**Re: Sandia Peak Grid BESS Facility
7880 & 7850 Jacs Lane NE
Traffic Circulation Layout
Engineer's Stamp 05-27-2022 (D16-D002A9)**

Based upon the information provided in your submittal received 06-06-2022, the above referenced plan cannot be approved for Building Permit until the following comments are addressed:

| | A | ISSUED FOR PERMITTING | | | 02/11/2022 | JB | PPG | WKW | TH | | FOR 24x36 DWG ONLY | | TRAFFIC CIRCULATION PLAN | | | | | |

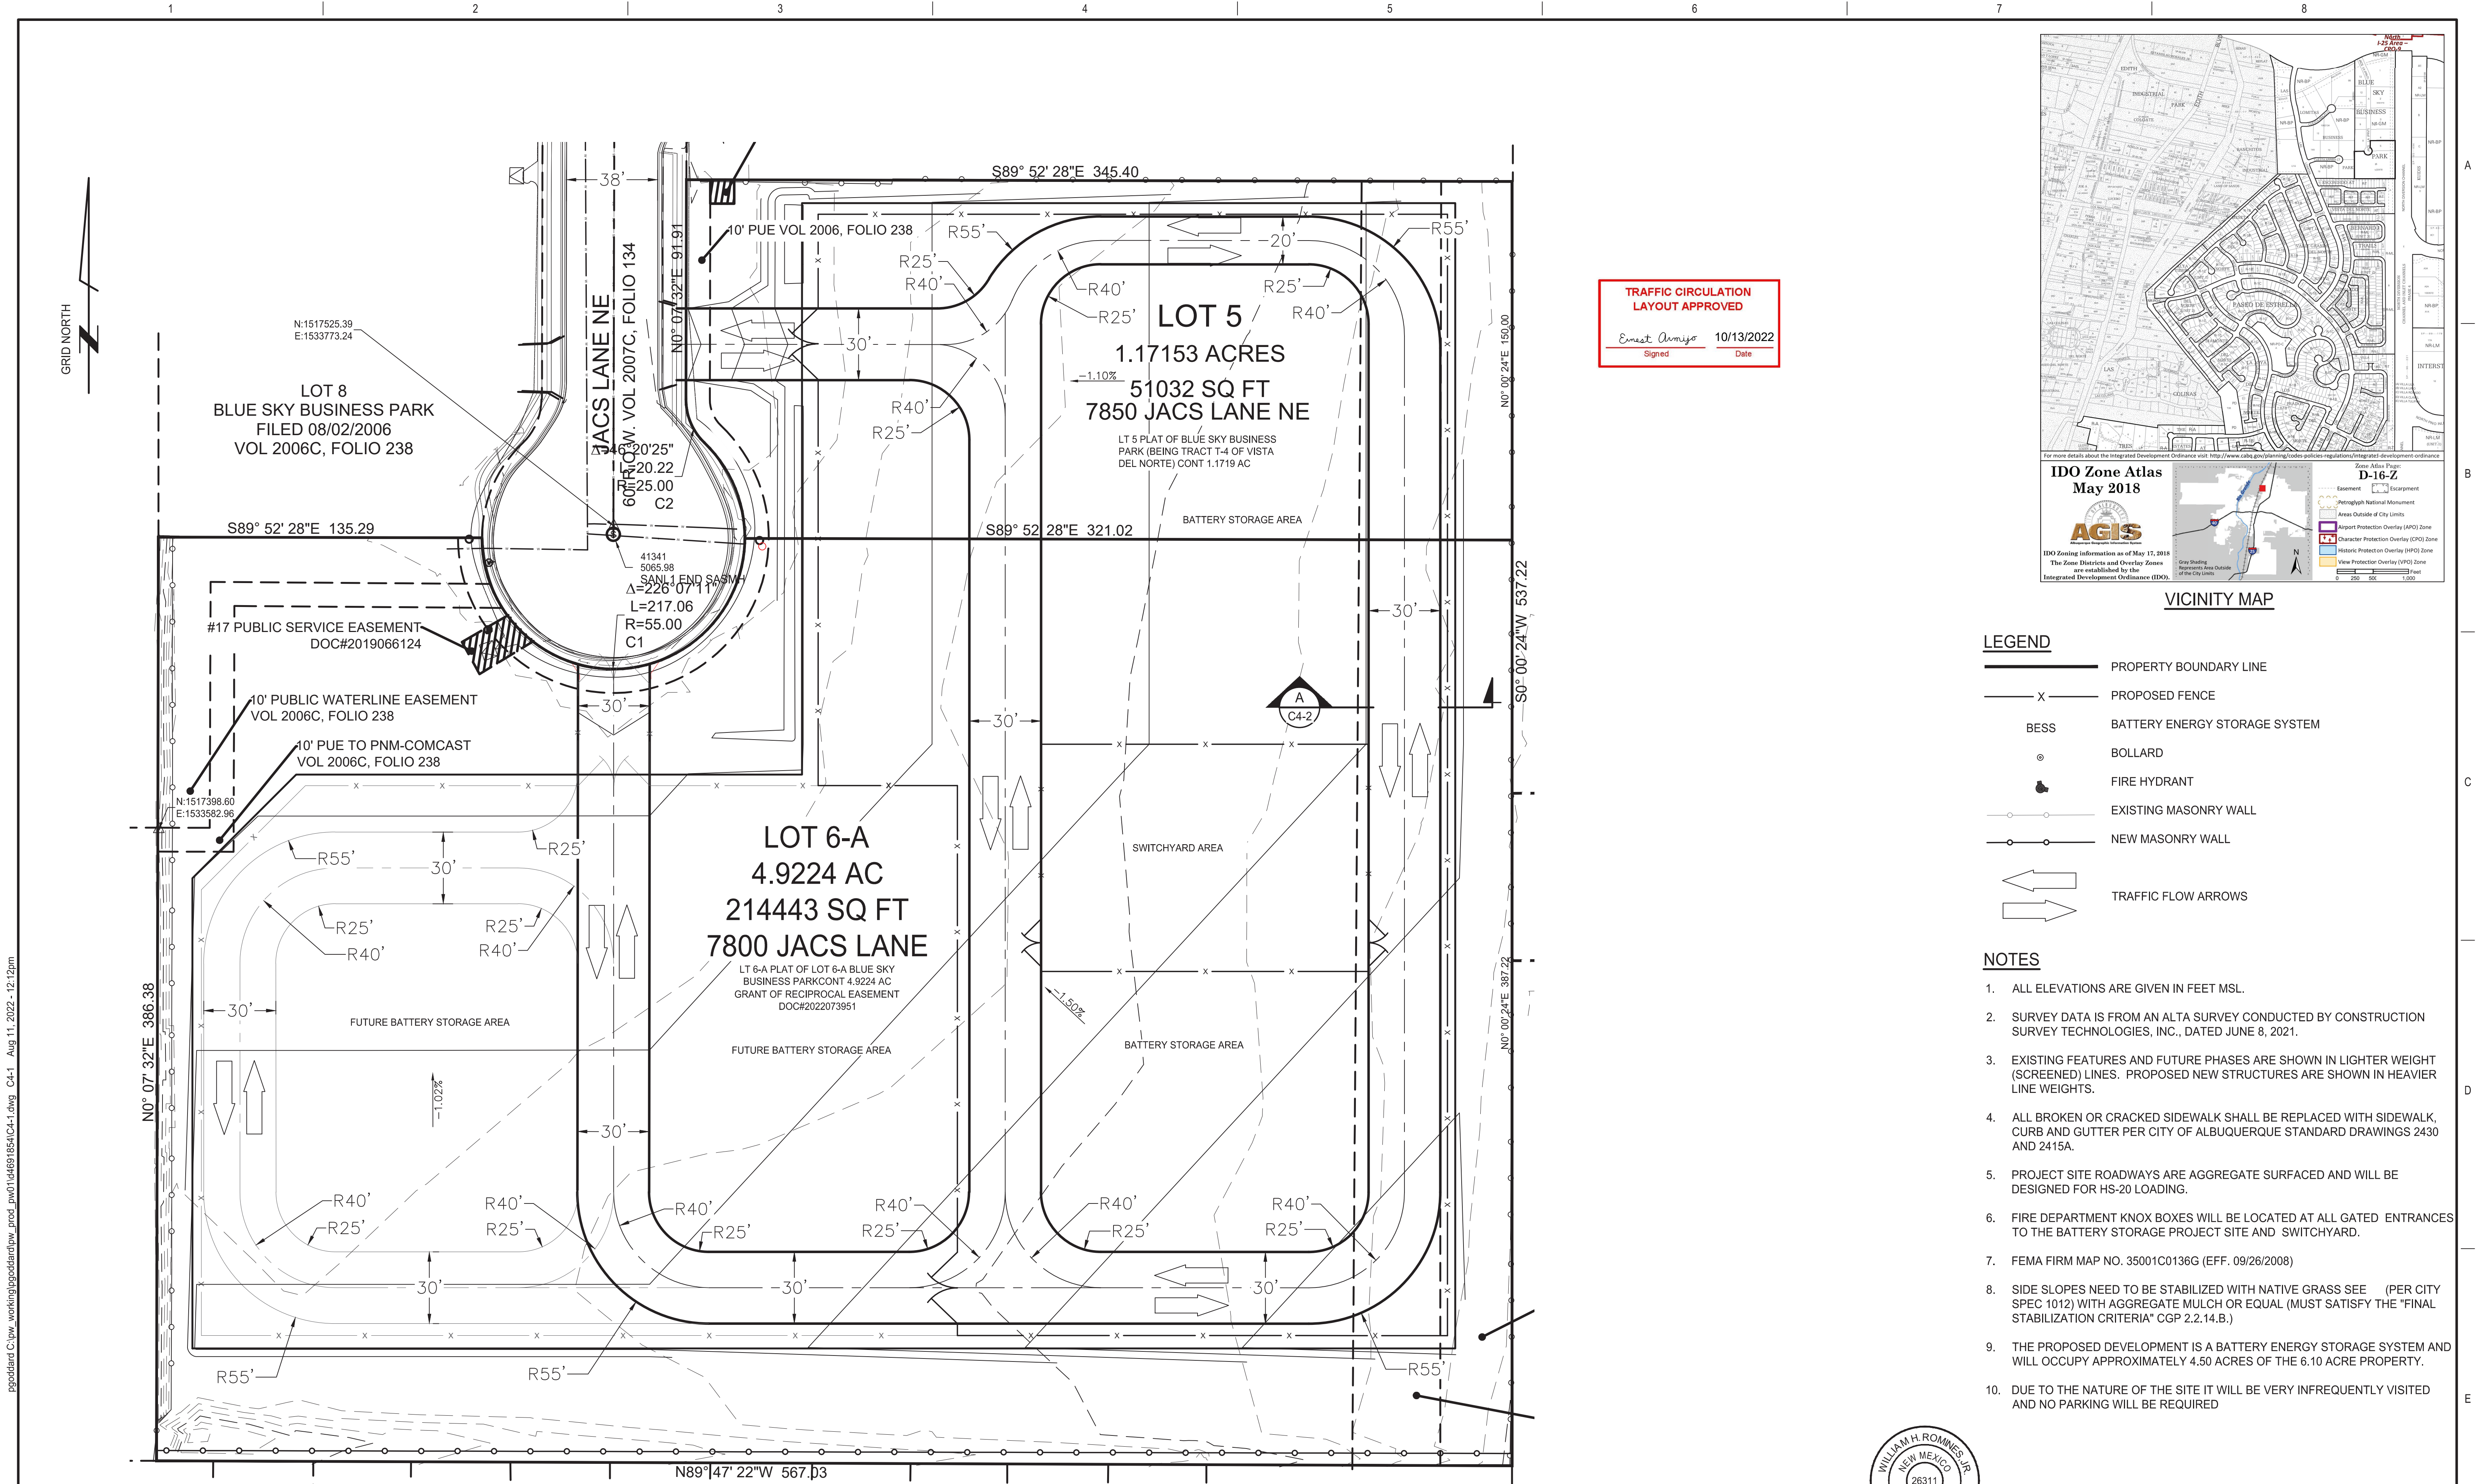
1. Sheet C4-1:

- Remove PRELIMINARY AND Not for Construction statement off this sheet.
- **Title Block:** Remove statement Conceptual.
- The above items will need to be remove in order for the approval of the **TCL (Traffic Circulation Layout)** Plan.
